## REPLY TO PRINCIPAL PLANNER/CONSERVATION OFFICER'S CONSULTATION RESPONSE RE PROPOSED WORKS AT THORNBERS, WADDINGTON, RIBBLE VALLEY, LANCASHIRE

This document has been produced in reply to the consultation response from Ribble Valley Borough Council's principal planner/conservation officer regarding specific aspects of the proposed works at Thornbers (application references 3/2018/0220 & 0221). The points are considered individually below. This statement is to be considered as a supplement to the heritage assessment produced by Garry Miller Historic Building Consultancy in June 2017 in support of the proposal. It should be read in conjunction with that report, along with other documentation submitted as part of the application.

Proposed Floor Plans
 DATE 13.07.18

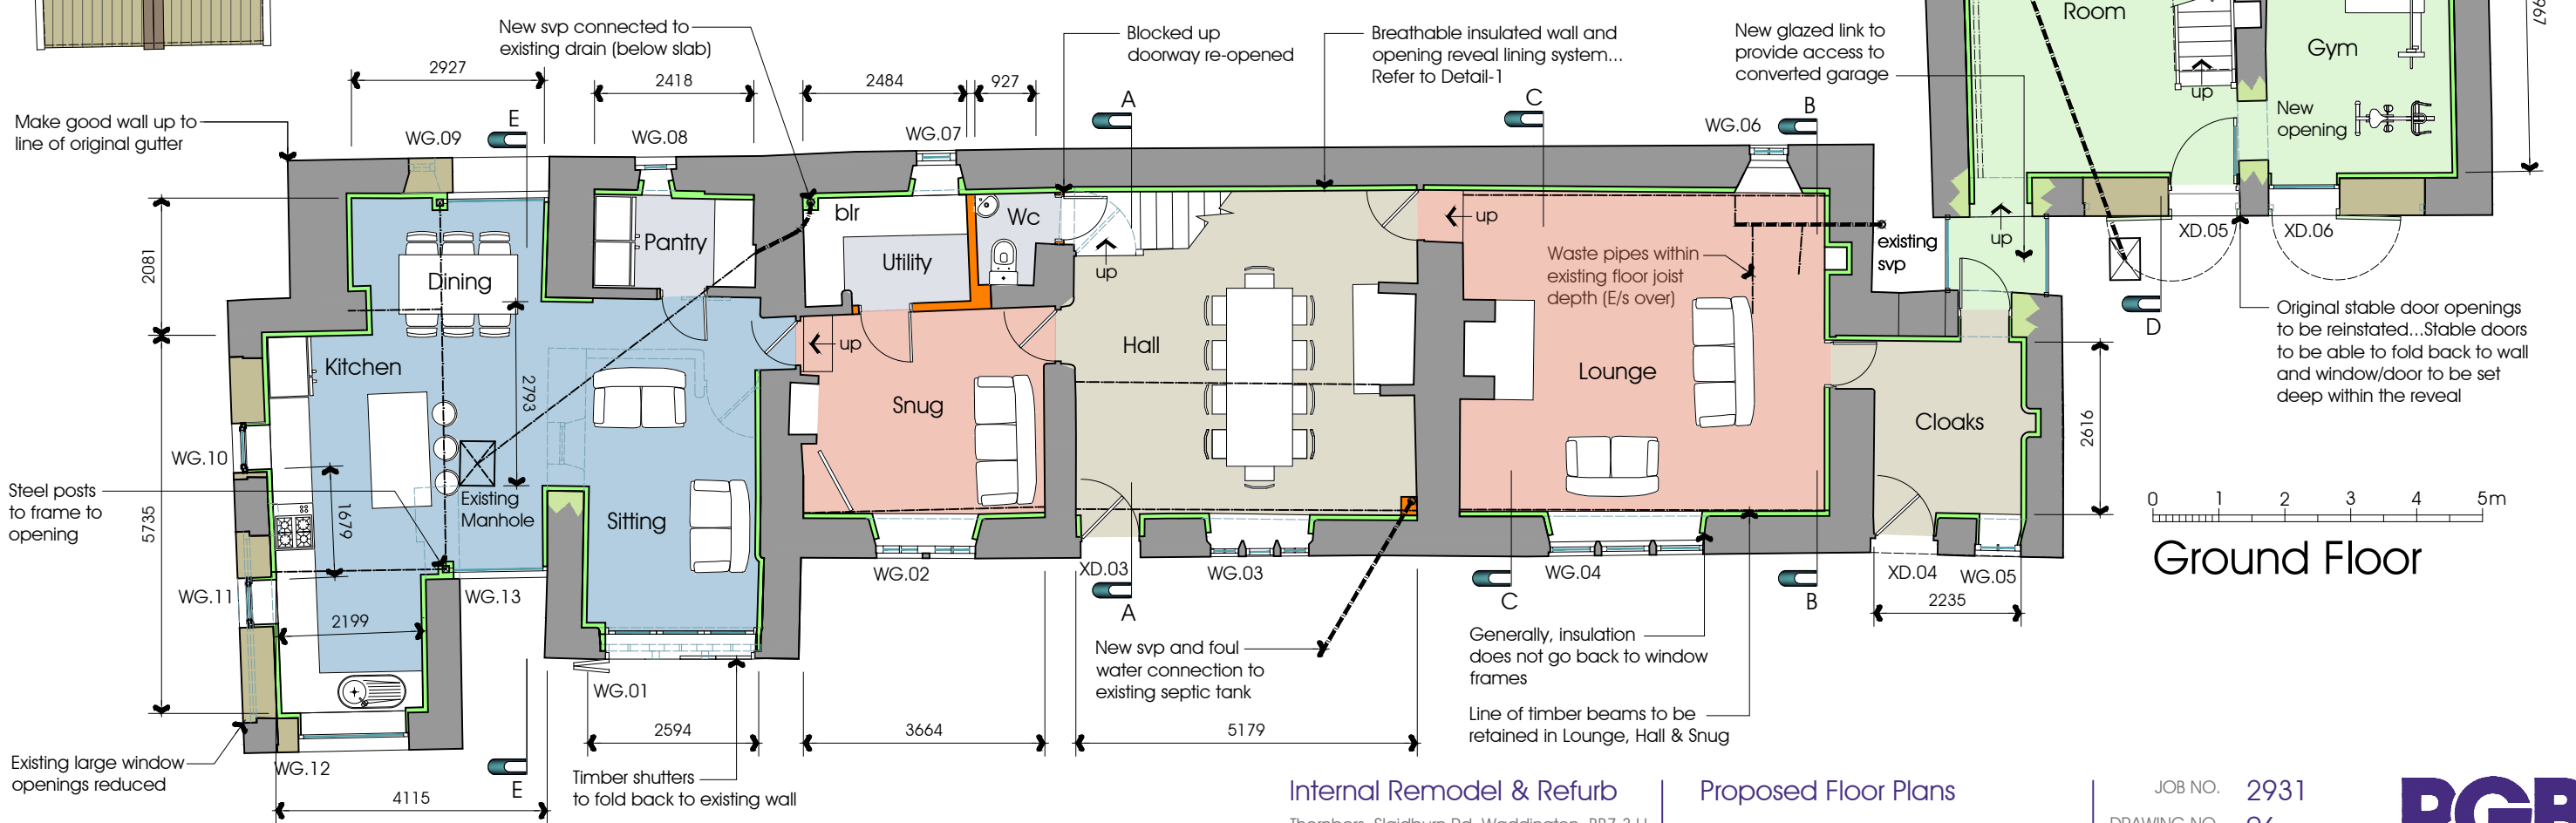
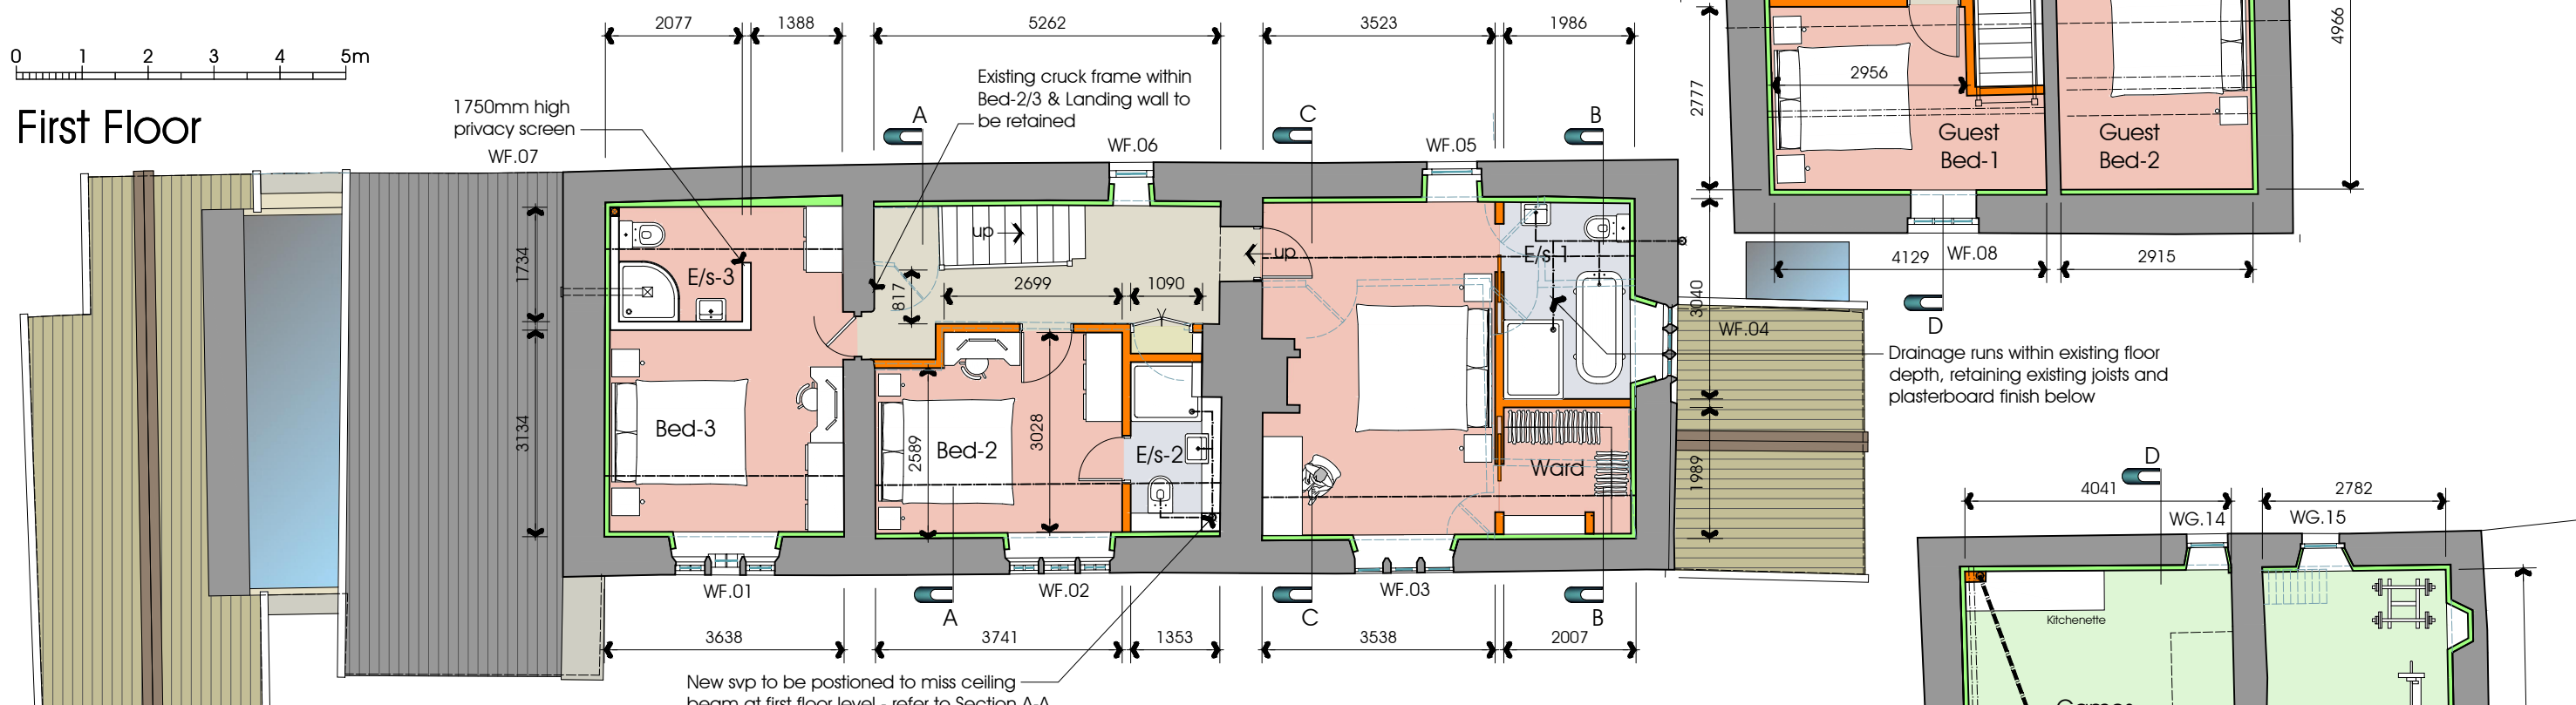
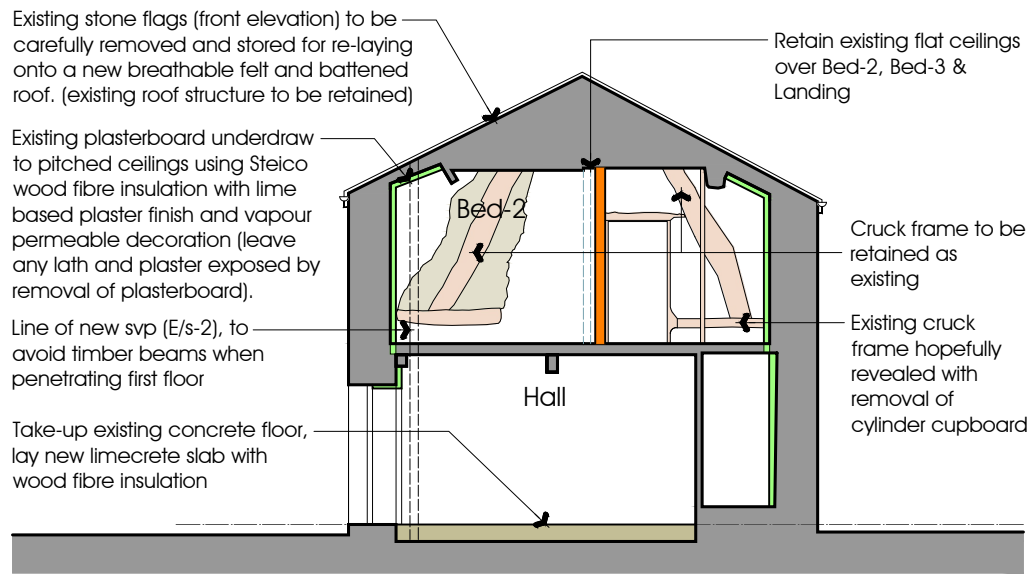
In the rear wall of the 19<sup>th</sup> century porch is a blocked doorway (Plate 1, page 3). This doorway will be reopened to accommodate the glazed link, but for alignment reasons will need to be shifted slightly to the east. This limited degree of harm is considered preferable to the alternative of intervention to the high-significance 17<sup>th</sup> century element of the listed building.

The original tall and narrow doorways of the stable are to be reinstated, in line with suggestion made by the principal planner/conservation officer. The significance of the building will therefore be enhanced.

Concern has been expressed over loss of the west wall of the former cartshed. This wall is now internal and shows some signs of rebuilding, with a 1970s/1980s opening inserted. In their consultation response, Lancashire Archaeology Advisory Service has suggested that the proposal be modified to retain nibs on either side of the opening. This approach has now been adopted and it is considered the reduction in the size of the opening is acceptable.

The principal planner/conservation officer has requested more information over whether the third bay at the east end of the building was a barn that was open to the roof. There is no direct evidence that this part of the building was originally used as such, but it is of course historically possible because cruck buildings often accommodated both domestic and agricultural functions under the same roof. The presence of the mullioned window suggests though that by the later 17<sup>th</sup> century the building was domestic use and a ceiling had been fitted within. However there is other evidence to indicate that the present underdrawn ceiling is not original and that its removal will not be harmful. This ceiling is of plasterboard laid beneath lath-and-plaster. The roof timbers above are of no great age, probably the early 20<sup>th</sup> century. It is most likely therefore that when the house was rebuilt in stone in the late 17<sup>th</sup> century the ceiling in the bedroom was open to the roof timbers. This ceiling was probably underdrawn when the corridor and bathroom and staircase were installed, i.e. probably the mid-later 20<sup>th</sup> century, as it would have been less straightforward to introduce the partition if the ceiling remained open. Removing the underdrawn ceiling will therefore not be harmful.

This is located on the first floor landing and conceals part of the northern blade of the cruck. The cupboard itself is probably 1920s/1930s, i.e. similar to the staircase. Its significance is therefore low. The removal of this cupboard is now sought, and in doing so it will reveal more of the cruck blade and therefore enhance the significance of the listed building.

South (front) elevation 0 1 2 3 4 5m

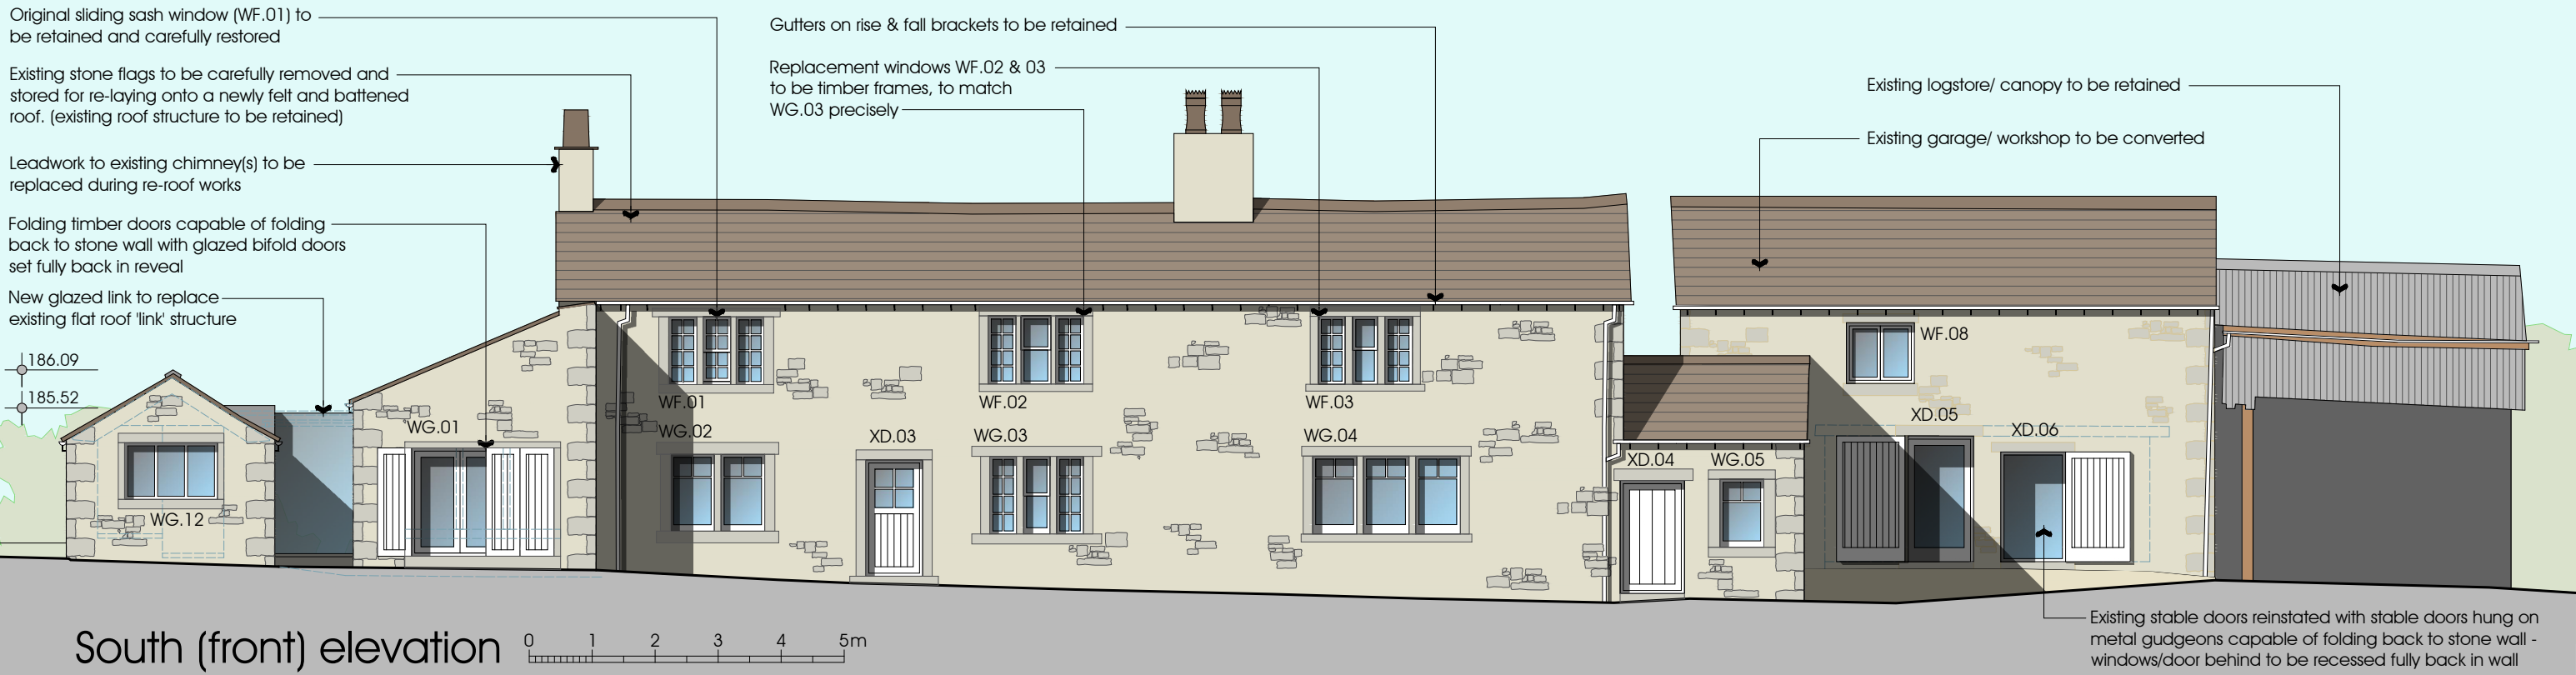
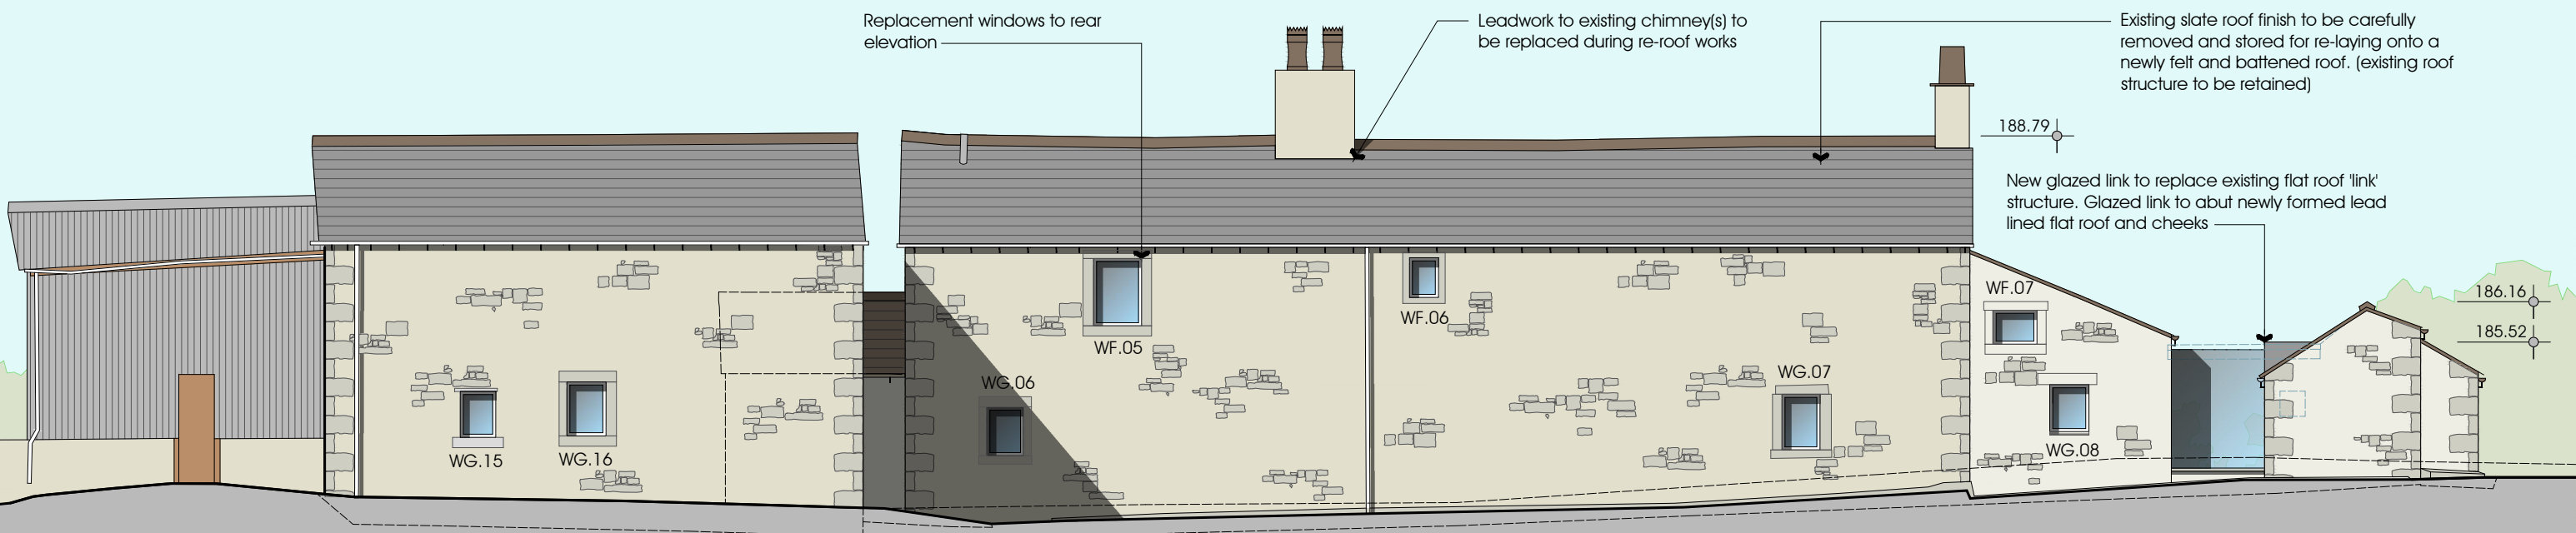
Further information has been requested upon the significance of the windows and how this has informed their replacements. The windows throughout the building appear to date from the 1970s/1980s refurbishment undertaken by the previous owners, with two exceptions: the ground floor window to the right of the entrance, and the first floor window to its left. Both of these are of three lights, with the central light of both having an earlier sash (probably 19<sup>th</sup> century): the ground floor window is of two lights (one over one) and the first of eight small panes (four over four, with some bullseye glass). The outer lights in each case are of eight 1970s/1980s fixed small panes. The significance of these early elements is therefore greater, and the proposal is to simply refurbish both of them. The 1970s-1980s windows will have new single-glazed framing, of a pattern to match the existing. The exception is the ground floor window left of the door, which differs from the other front elevation windows in its proportions and that it is of two (slightly wider) lights. The proposal here is to replicate the framing pattern of the three-light ground floor window of the third bay, whose proportions are similar; both windows were probably modified/inserted at a similar date. The window will therefore have two panes above a large single pane in both lights.
